CITY OF
Albuquerque
October 22, 1996

**RE: MADRID STAT FARM (D13-D1D). ENGINEER'S CERTIFICATION FOR
CERTIFICATE OF OCCUPANCY APPROVAL. ENGINEER'S CERTIFICATION
DATED OCTOBER 9, 1996.**

RE: GRADING & DRAINAGE PLAN FOR MADRID STATE FARM (D-13/D1D)
RECEIVED APRIL 25, 1996 FOR BUILDING PERMIT
ENGINEER'S STAMP DATED 4/22/96

RE: GRADING & DRAINAGE PLAN FOR MADRID STATE FARM (D-13/D1D)
RECEIVED MARCH 5, 1996 FOR BUILDING PERMIT
ENGINEER'S STAMP DATED 3/1/96

MADRID STATE FARM OFFICE BUILDING
GRADING & DRAINAGE PLAN

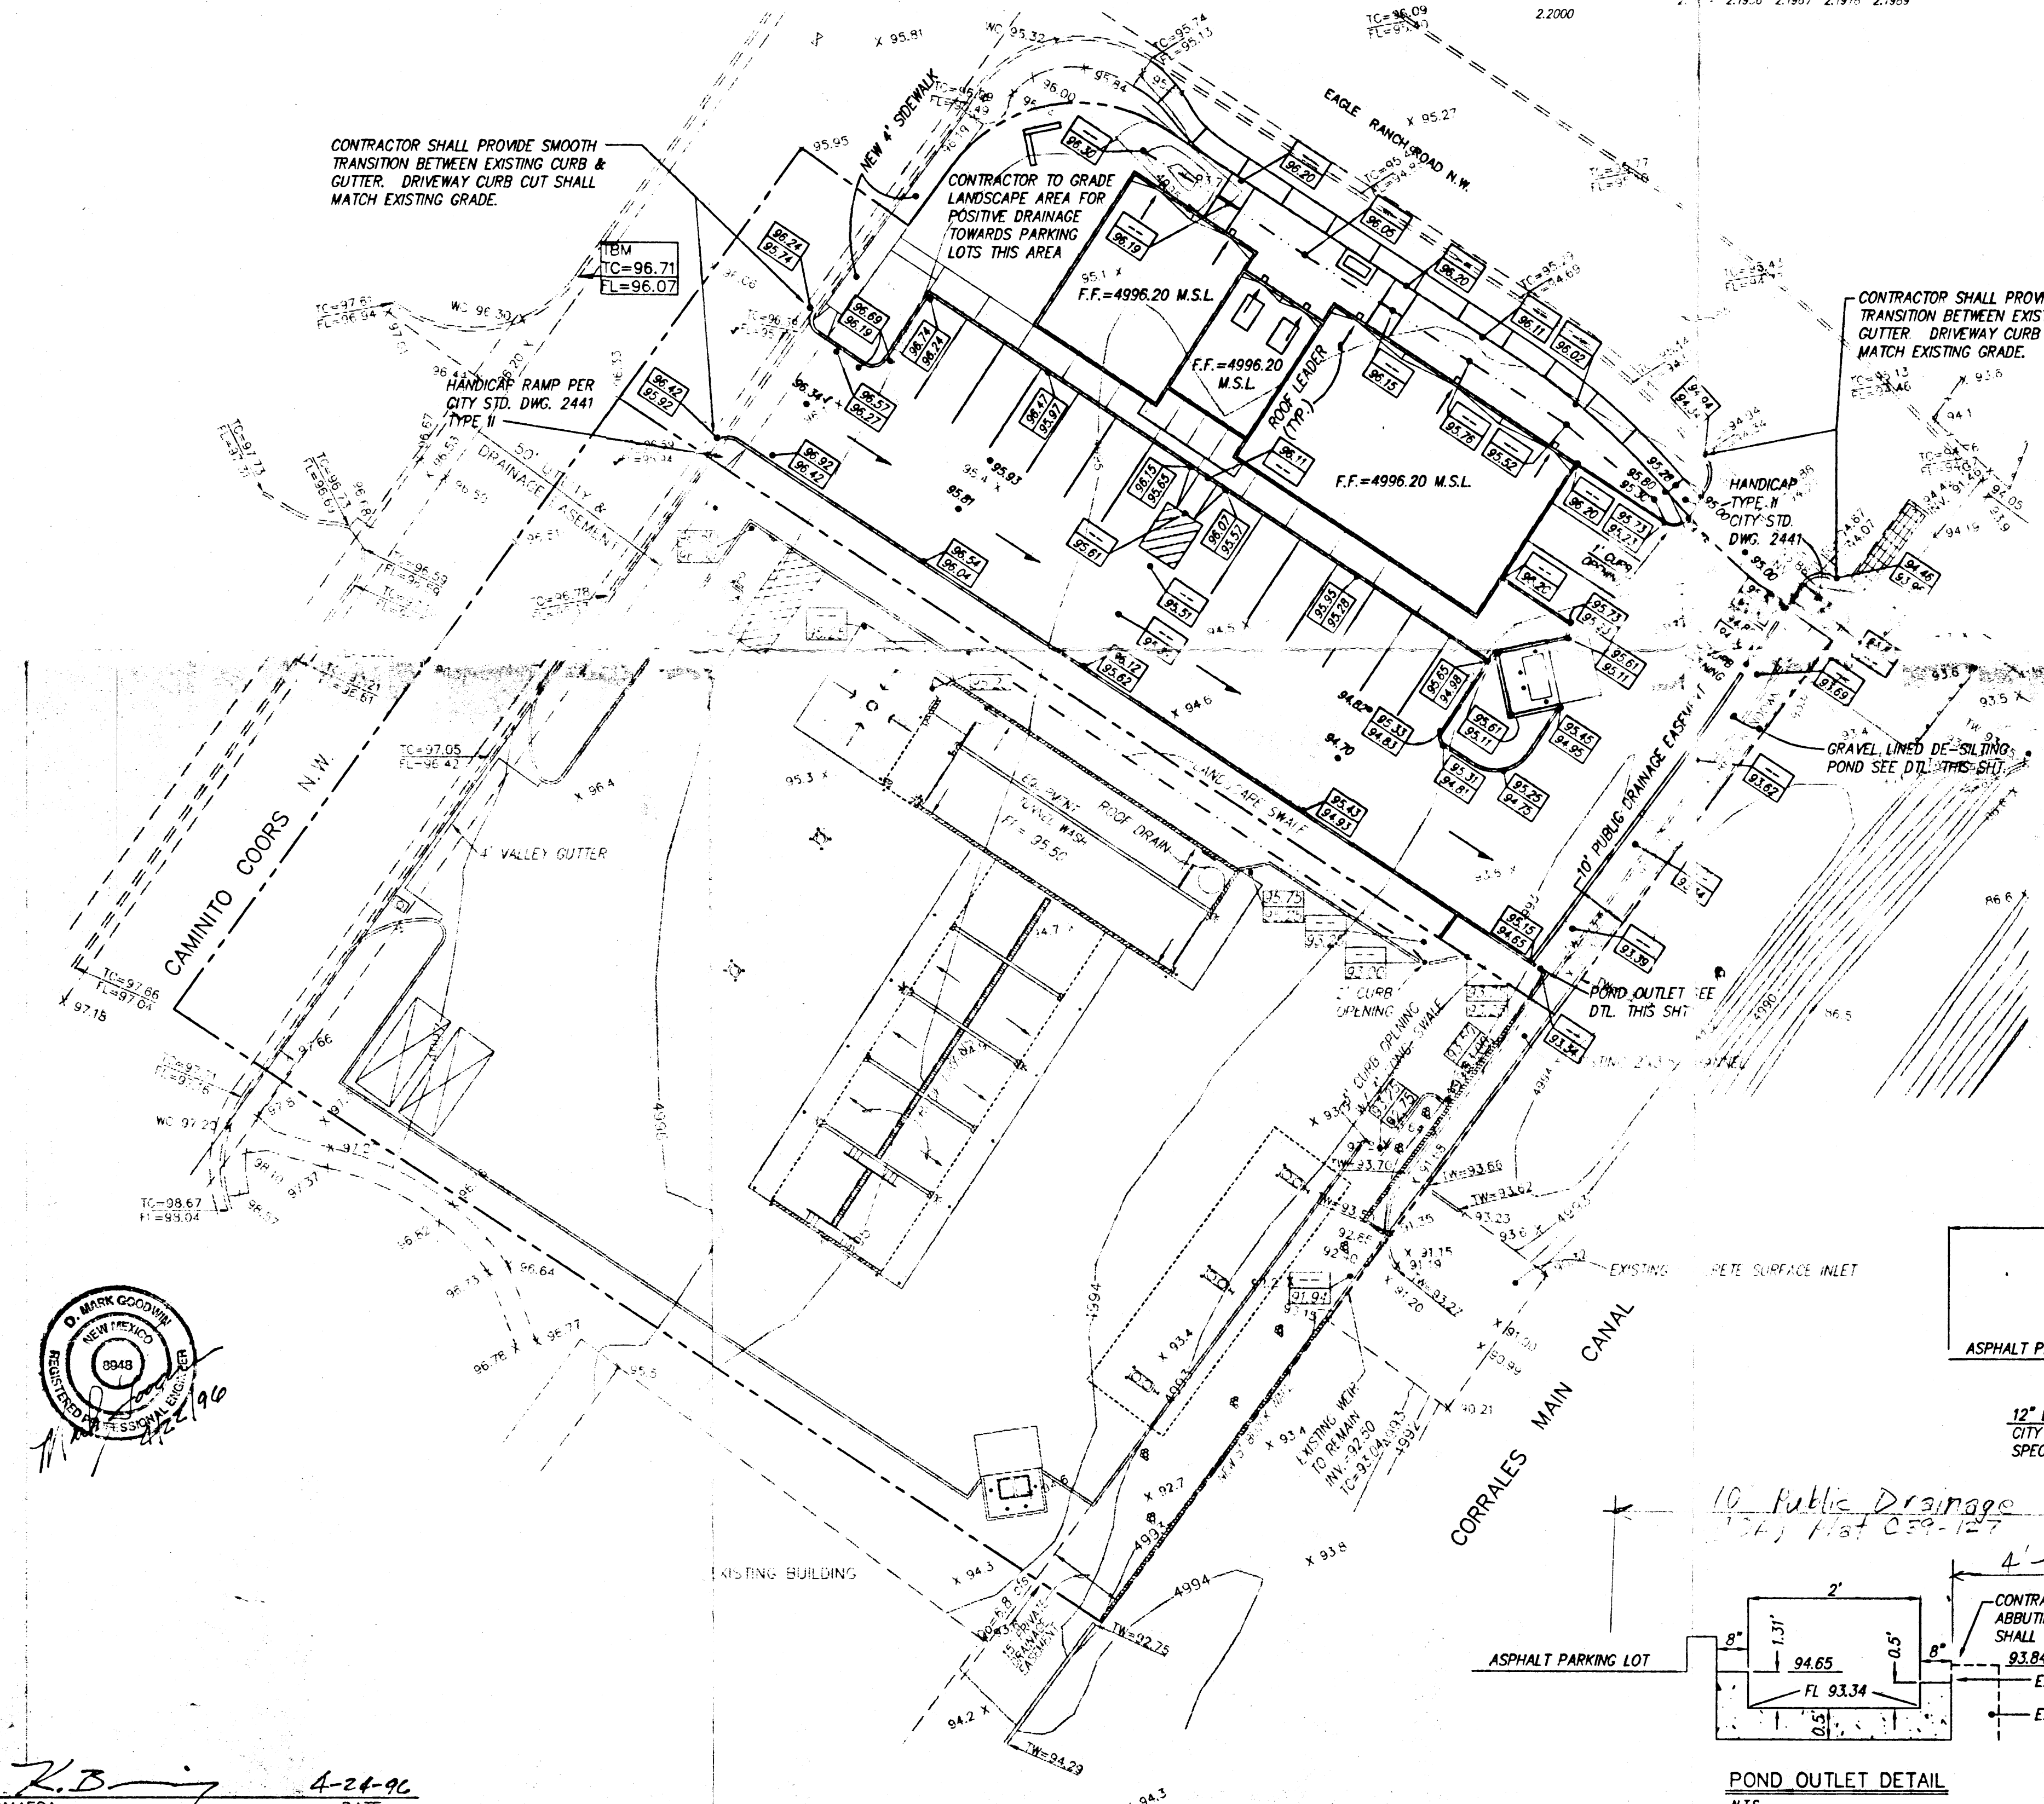
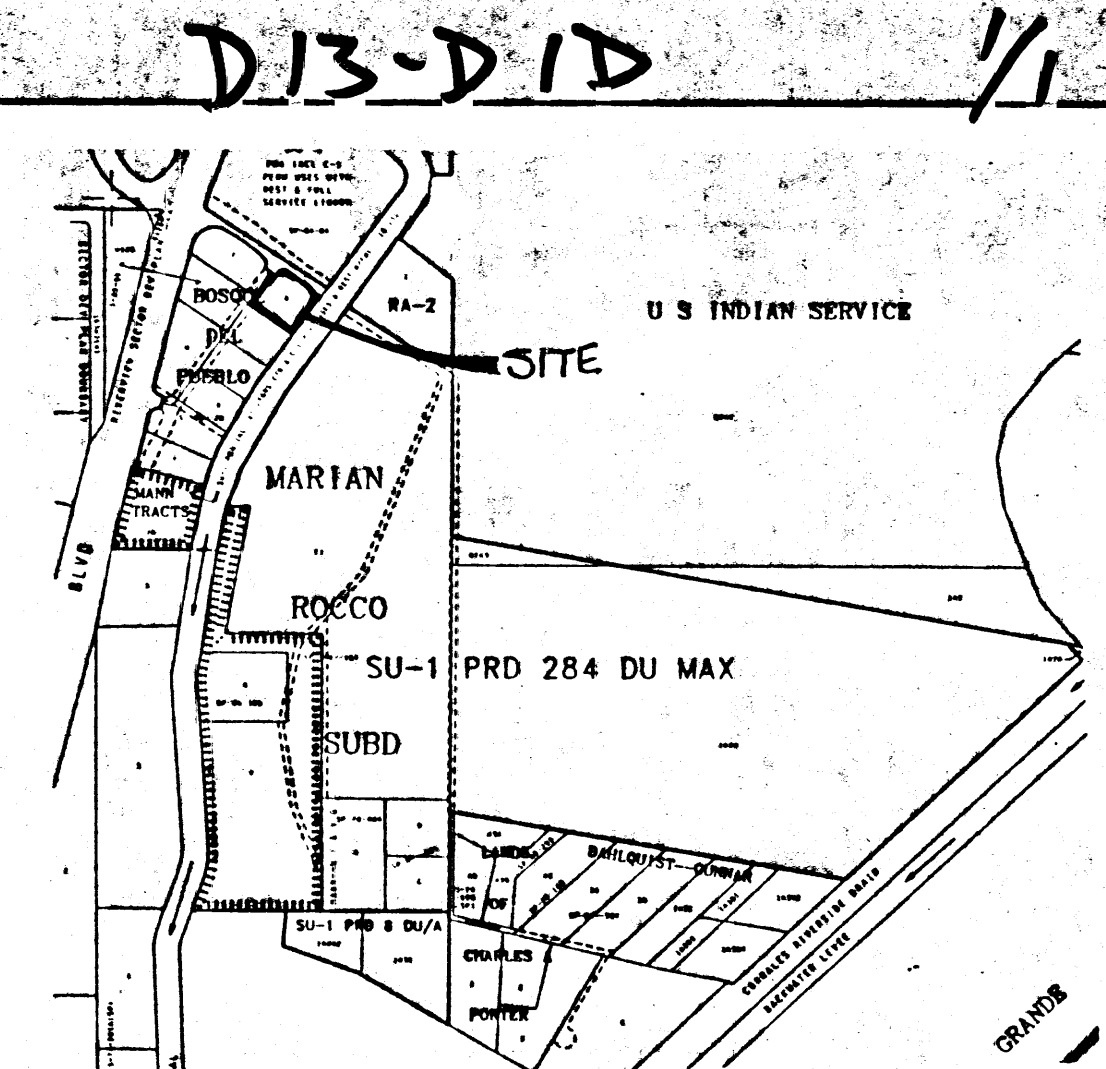
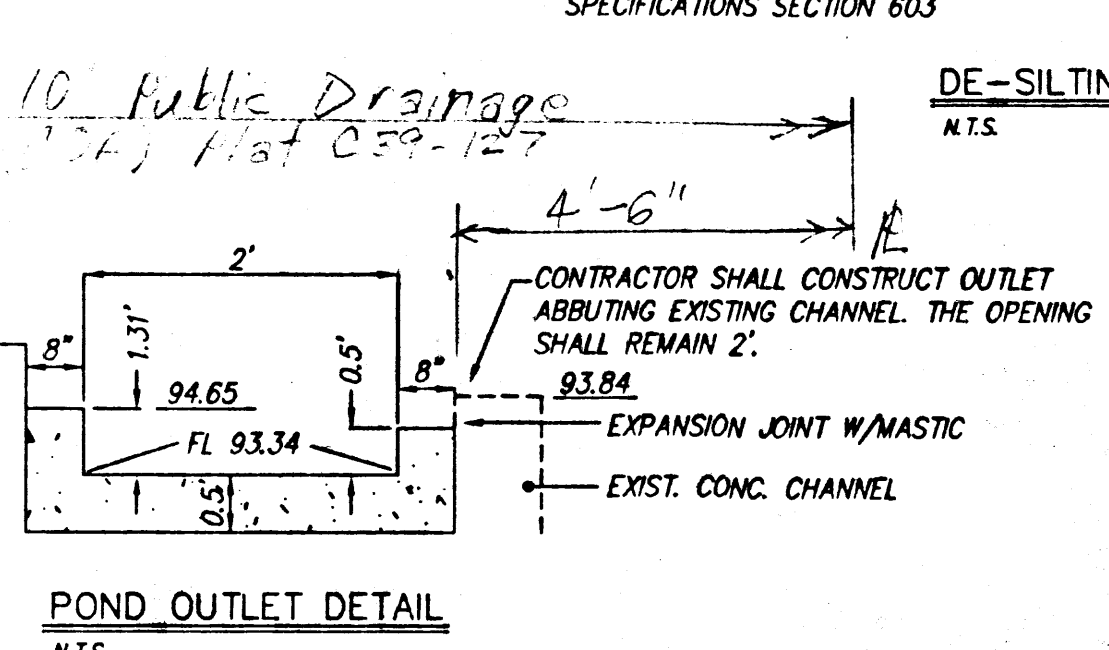
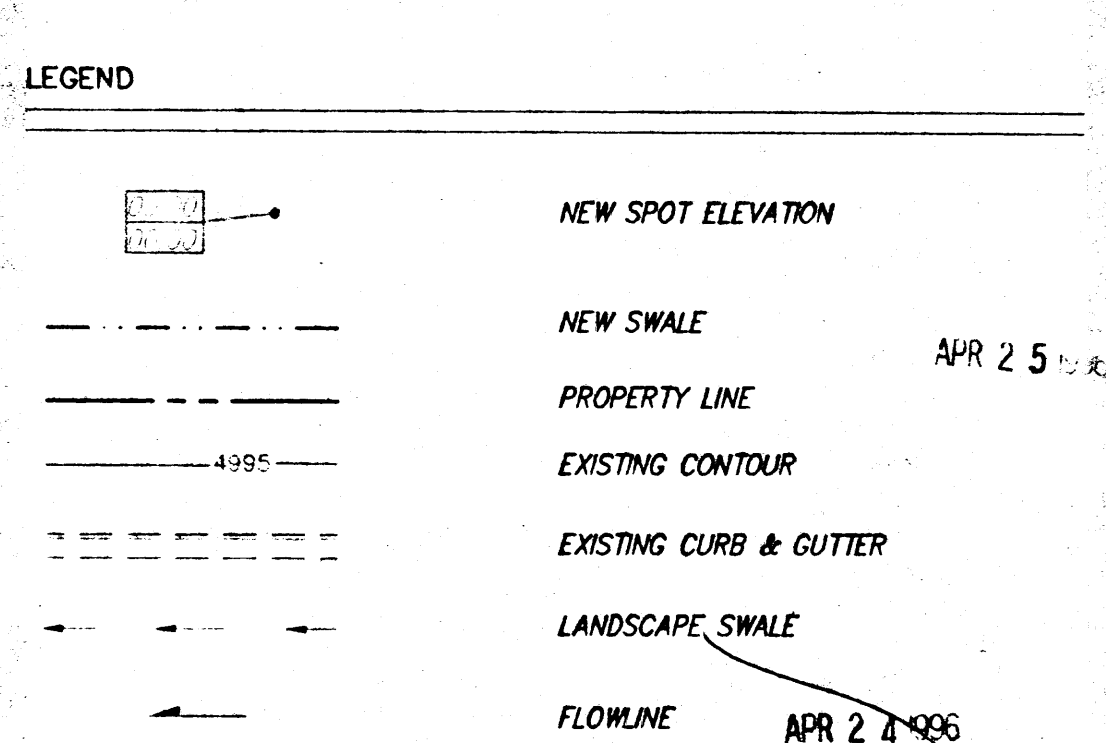
The Plat of Tracts 3A, 4A, 5A, 6A Bosque Del Pueblo indicates that there is a 10' Public drainage Easement along the southeast side of Tract 6A. Indicate this easement on the Plan. Any work within this easement must be approved by Glenn Jurgensen.

The de-silting pond is confusing (see attached mark up). Call outs for details should match the title of the detail. What is the retention time? Will the multiple inlets short circuit the pond? Submit the calculations necessary to meet the Bosque Del Pueblo master plan criteria. Verify that water blocks are adequate.
